From: Joanne Lewis <Joanne.Lewis@arun.gov.uk>
Sent: 05 August 2020 08:14
To: Planning.Responses <Planning.Responses@arun.gov.uk>
Subject: RE: Planning Consultation on: BN/81/20/DOC

I have reviewed the details submitted to discharge condition 4 - Construction Management Plan. However, I find that there is insufficient detail to enable this condition to be discharged for the following reasons as numbered on the construction management plan;

Application No: BN/81/20/DOC

Site Address: Swallowfield Eastergate Lane Eastergate PO20 3SJ

title
Proposed Construction Management Plan

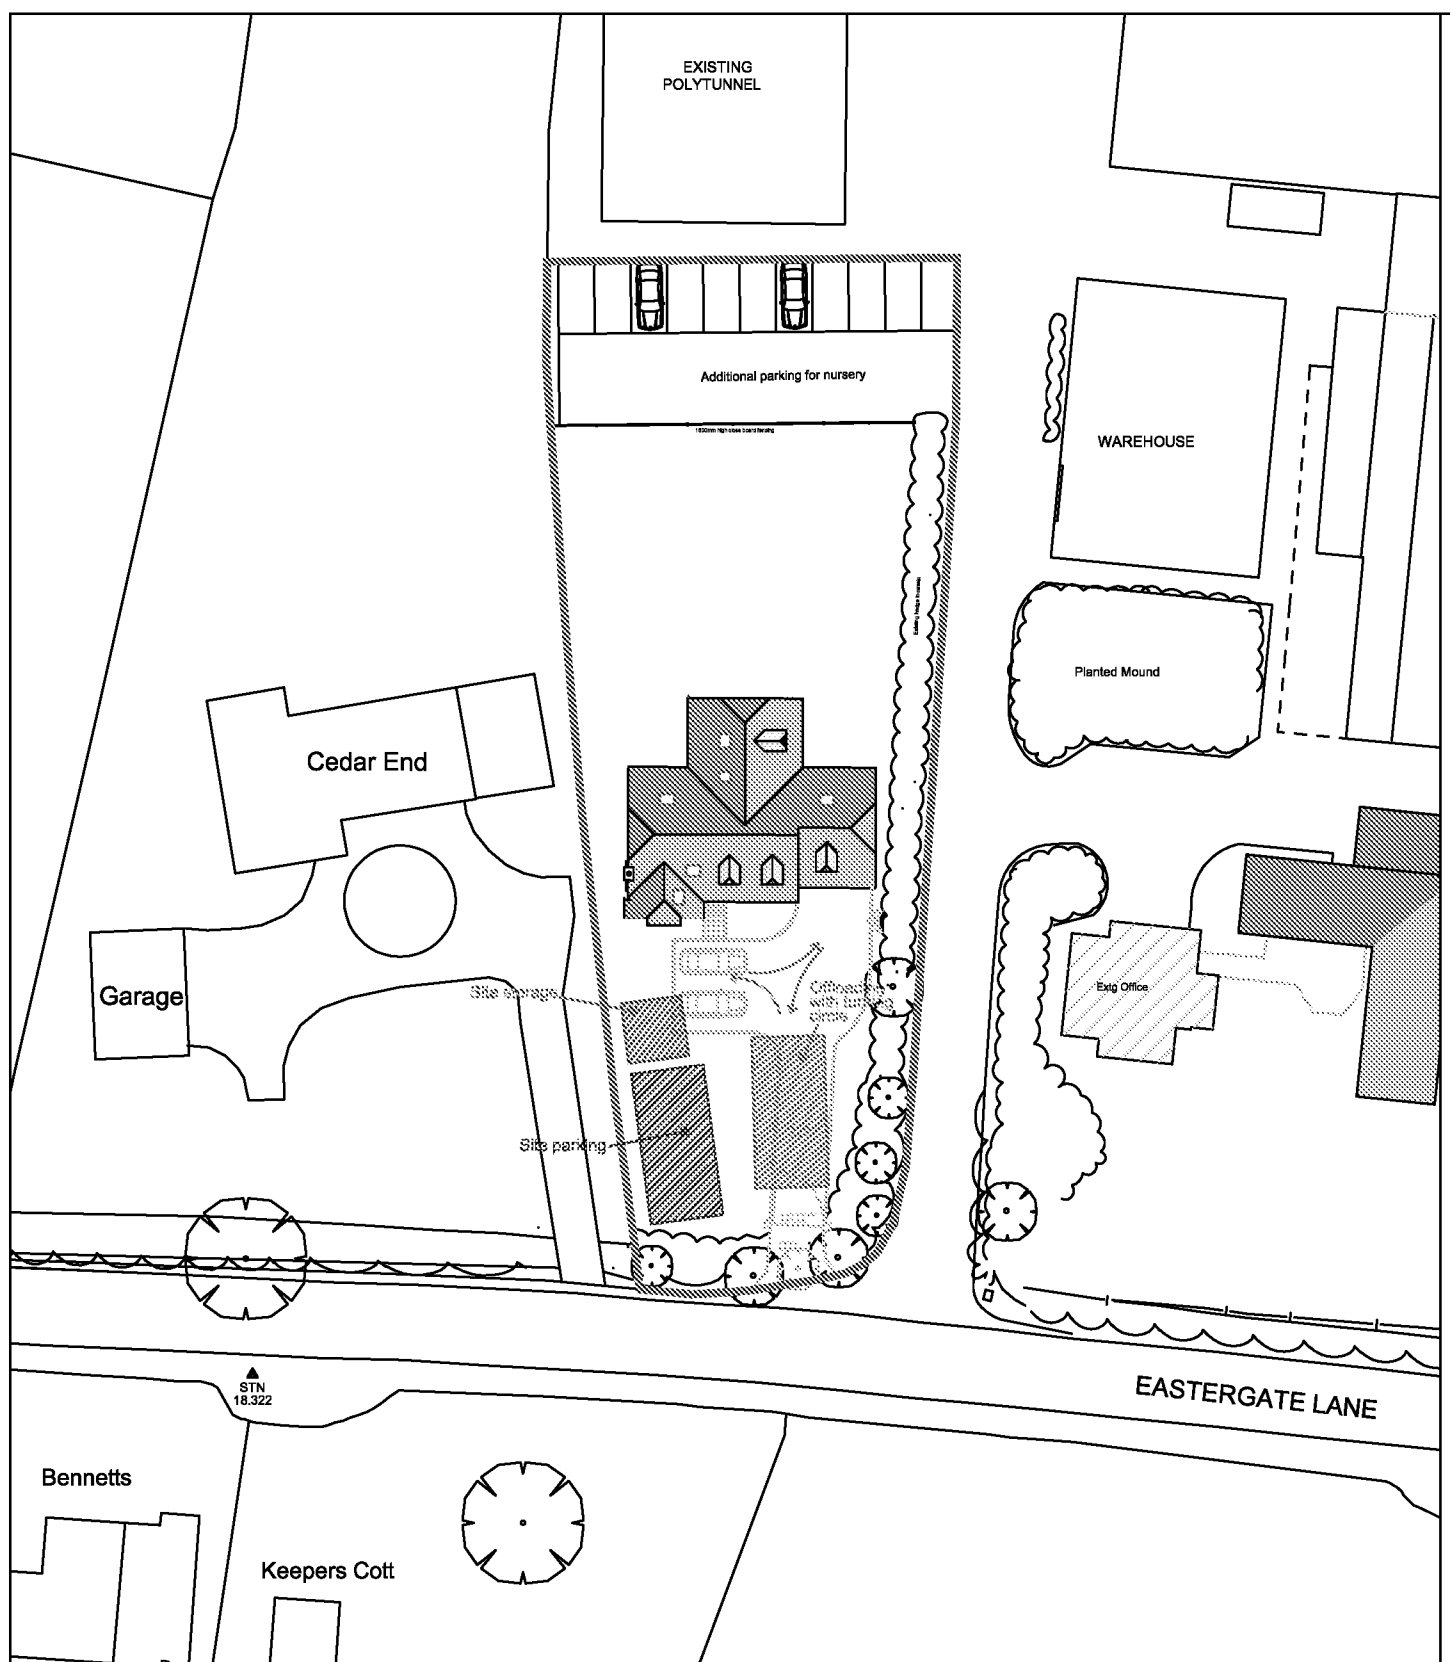
- a) I can not see an indicative programme for carrying out the works
- b) The site is adjacent to and opposite residential properties. It is essential that some level of communication takes place with these residents to ensure that residents know what to expect and who to contact should they be affected by the development
- c) Please provide more detail here including hours of work and other measures taken to control noise from equipment, vocal noise, vehicle noise etc
- f) Please provide details on timings for deliveries and how these will be controlled to minimise disturbance to local residents
- h) Heras fencing is not sufficient to protect the adjacent residents from noise and dust from the site. If there is no other fence/boundary currently in place a more solid hoarding needs to be provided along any site boundary that adjoins residential premises.
